From: Richard Temple
Sent: 12 February 2018 15:14
To: Planning.Responses
Subject: FW: FP/297/17/HH

Subject: RE: FP/297/17/HH

The above application at 15 Kingsmead, Felpham has popped up on my list to comment. As it's a minor application and isn't showing as being in an area of surface water flood risk it's not one we'd comment on but just thought I'd see if it was one on your radar? There's mention of a flood bank although presumably this is related to the fluvial risk from the Rife.

DRAWING TITLE
**SUMMERHOUSE
FLOOR PLAN / SITE PLAN**

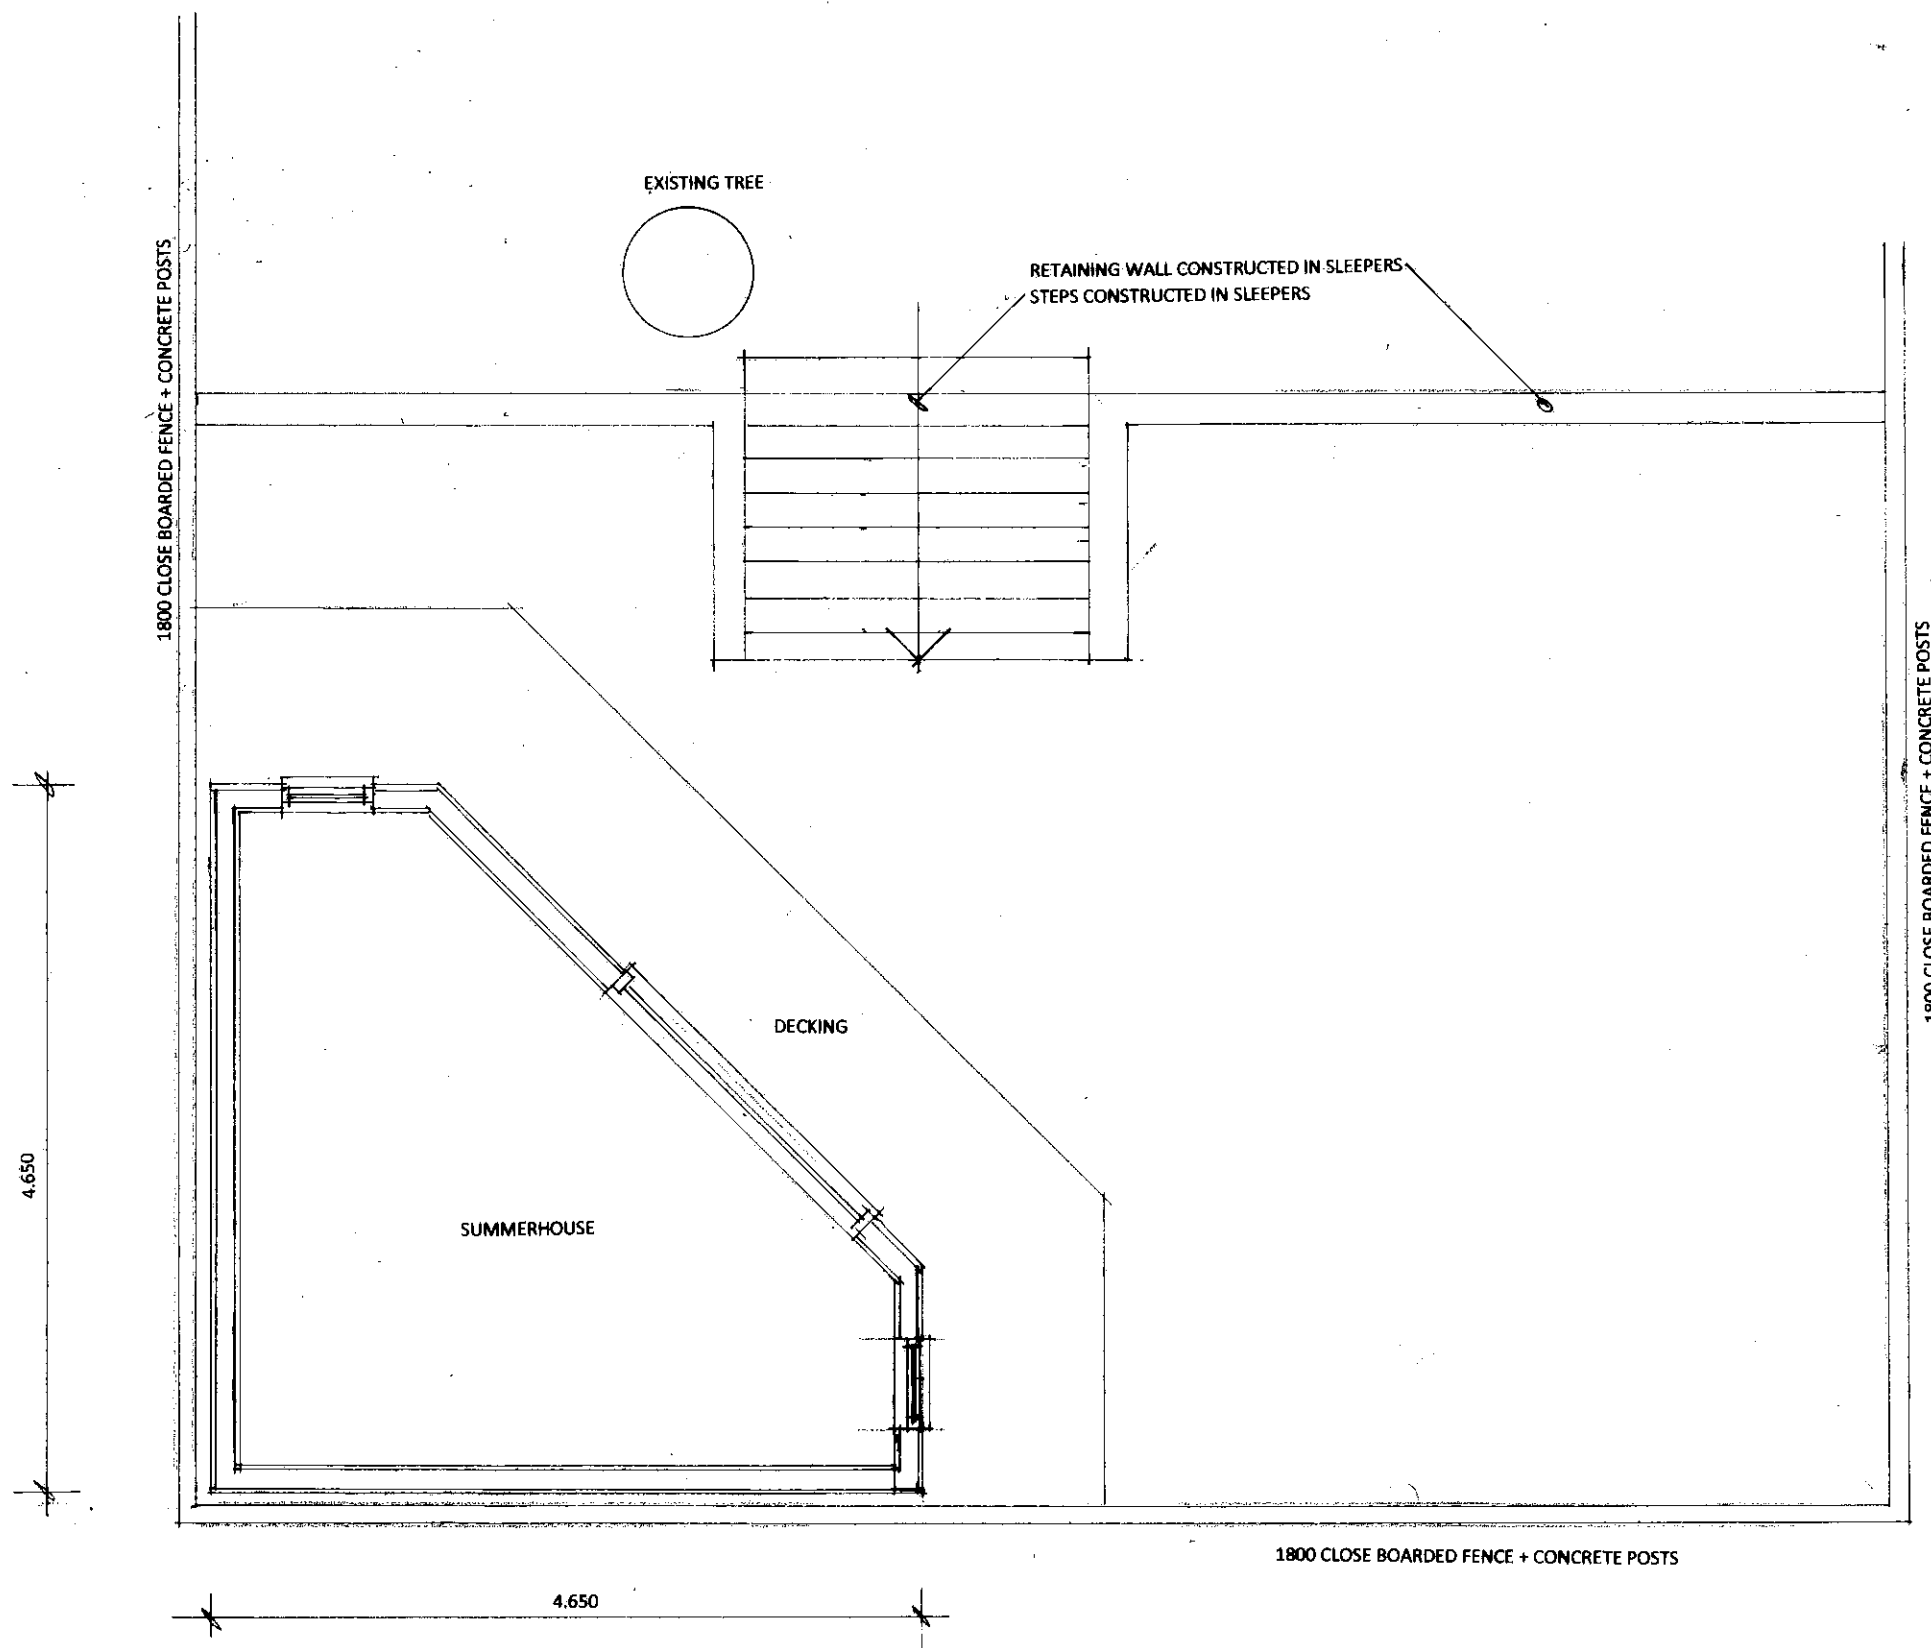
They've built on the flood bund. I attach a picture.

Not on my radar, but as they seem to be building on top of the flood protection bank (yes fluvial protection from the river), perhaps the Environment Agency should be consulted, to ensure there is no detriment to the flood defence structure.
